APPENDICES **A - G**

Re: Exhibition of Environmental Assessment – Project Application for Stage 1 & 1A of the Redevelopment of Wagga Wagga Base Hospital, Edward Street, Wagga Wagga (MP11_0087).

**MP11_0087 – PROPOSED REDEVELOPMENT OF WAGGA WAGGA BASE HOSPITAL –
STAGE 1A, EDWARD STREET, WAGGA WAGGA.**

FIGURE 27: Replacement Car Park

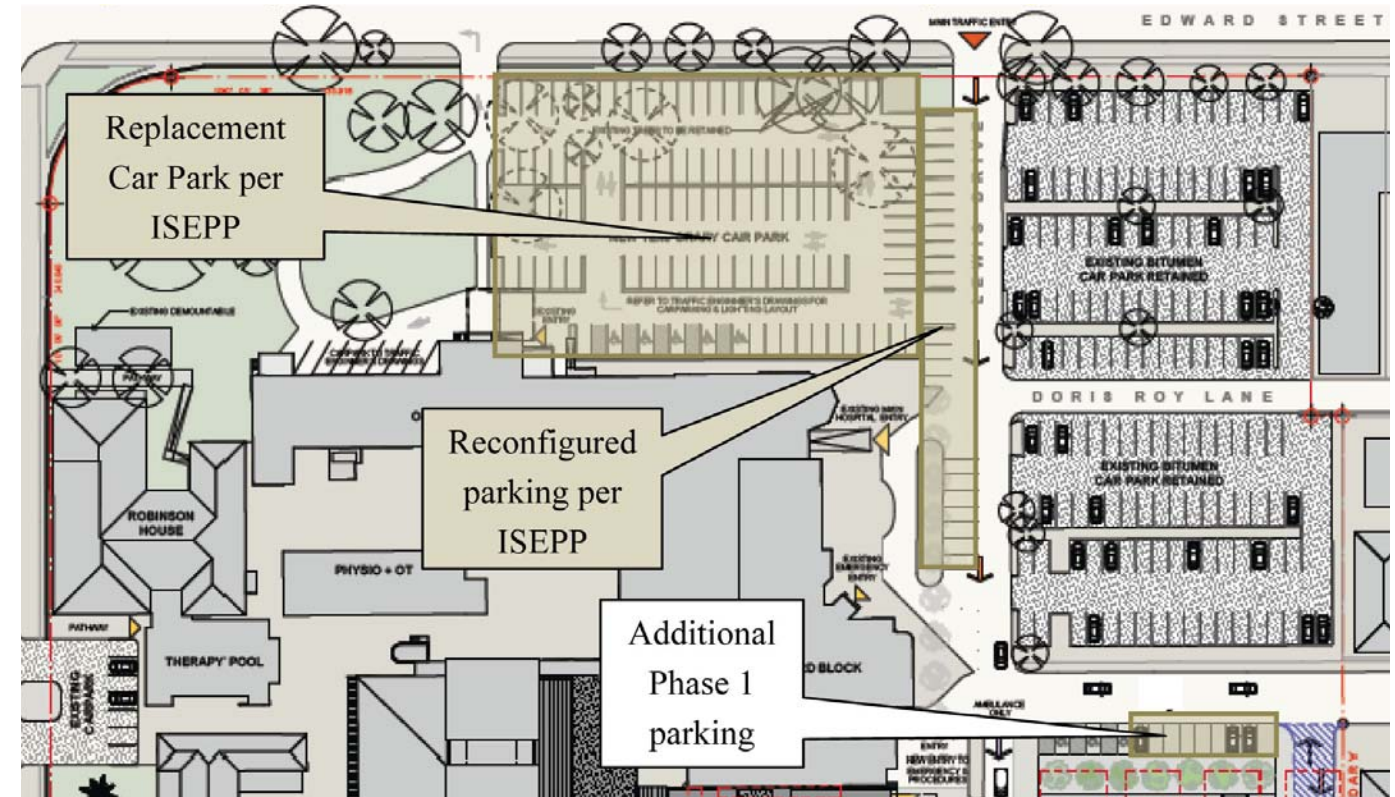
The exhibited documents proposed 2 different layouts for the carparks along the Edward Street frontage of the hospital site. It is understood that the carpark design for the existing and proposed carpark along the frontage of the hospital site to Edward Street is to be as per the layout on plan AR.GE.70.7001 Issue F included in the Test of Adequacy document dated November 2011. RMS notes that the proposed carpark works are being undertaken under the provisions of State Environmental Planning Policy (Infrastructure). RMS generally supports the proposed layout of the new carpark to the western side of Lewis Drive and the changes to the carpark on the eastern side of Lewis Drive and offers the following comments:

- The closure of vehicular access between the northern most aisle of the existing carpark located in the north eastern corner of the site and Lewis Drive is supported. To allow for ease of circulation within the carpark the provision of left turn egress only from the carpark to Lewis Drive and one-way circulation should be considered. The kerb and gutter and signage could be designed and located to support this and deny left turn from Lewis Drive into this carpark.

- The removal of the existing 90 degree parking located along the western side of Lewis Drive as shown on plan AR.GE.70.7001 Issue F is supported
- The location of one access from Lewis Drive to the new carpark to be constructed in the north western precinct of the site at the southern most aisle is supported.

- The existing driveway egress from the proposed new carpark to Edward Street should be deleted if it is not required for emergency purposes. Notwithstanding this, this driveway is to

be restricted to authorised vehicles by appropriate means, such as boom gate, as there would be a tendency for visitors parking within the new carpark to use this existing driveway. As a minimum signage is to be erected denying access to Edward Street is to be erected.

- To improve the traffic management and interaction with the existing road network RMS would consider an option for the construction of a driveway connection from the new carpark to Docker Street. To maximise the separation of a new driveway to Docker Street from the nearby traffic signals at the intersection of Docker and Edward Streets the driveway would need to be located at the western extension of the southern east west aisle within the new carpark. This option would require the one-way movement within the carpark as proposed, an appropriately designed driveway treatment in Docker Street and traffic calming devices to minimise speed for through vehicles between Lewis Drive and Docker Street. To remove the driveway to Edward Street and provide access to Docker Street may allow for additional parking spaces or landscape provision to be provided.

- The layout of the proposed carpark should comply with the provisions of AS 2890.1-2004 "Off-street car parking" and be designed and provide facilities for safe pedestrian movement though the carpark to the entrance to the Hospital.

- Provision for appropriate illumination and surveillance of the carpark is required.

FIGURE 28: Proposed Phase 1 Traffic Circulation

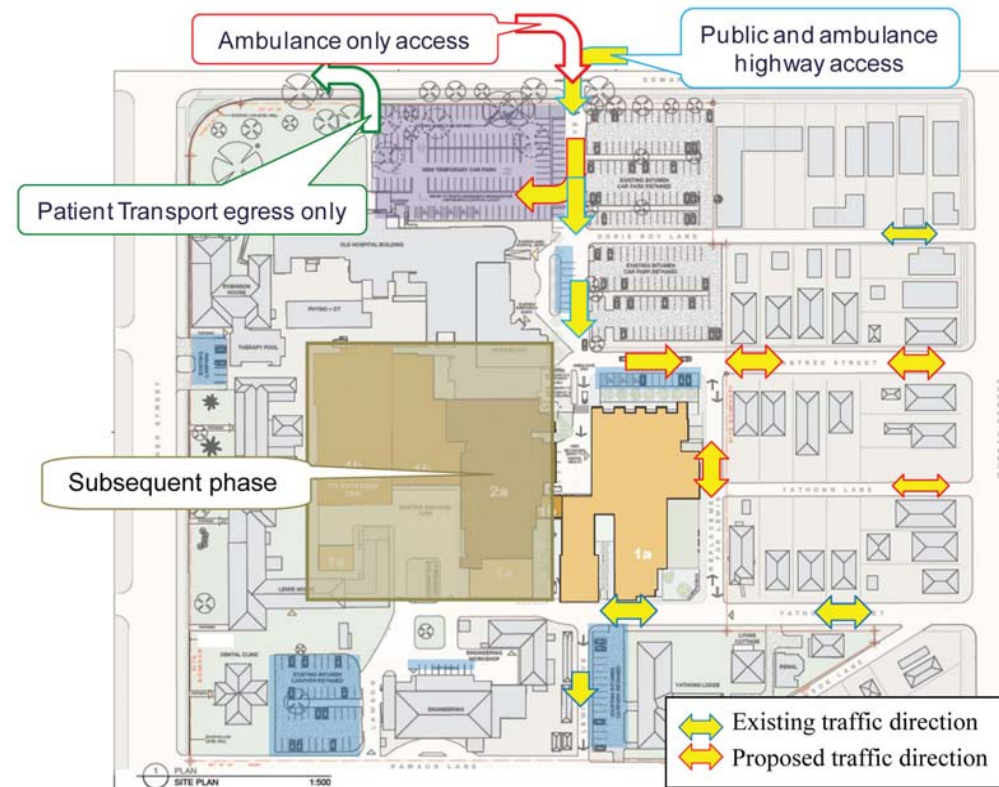
To provide for onsite circulation without the need to access the public road network and for ease of way finding within the site the proposed new road between Yathong and Yabtree Streets to the east of the Mental Health Building needs to provide for 2 way movement, not one-way as proposed in the Test of Adequacy document dated November 2011. This will also benefit circulation within the site and access for delivery vehicles when Yathong Street is extended to intersect with Docker Street. Representatives from NSW Health Infrastructure have advised that this roadway is to provide for two-way movement as the proposed width of 7m can catered to this.

- a. The new internal road located to the east of the Mental Health Building between Yathong and Yabtree Streets is to be designed, constructed and line marked to provide for 2 way movement for all vehicles likely to access the hospital site.
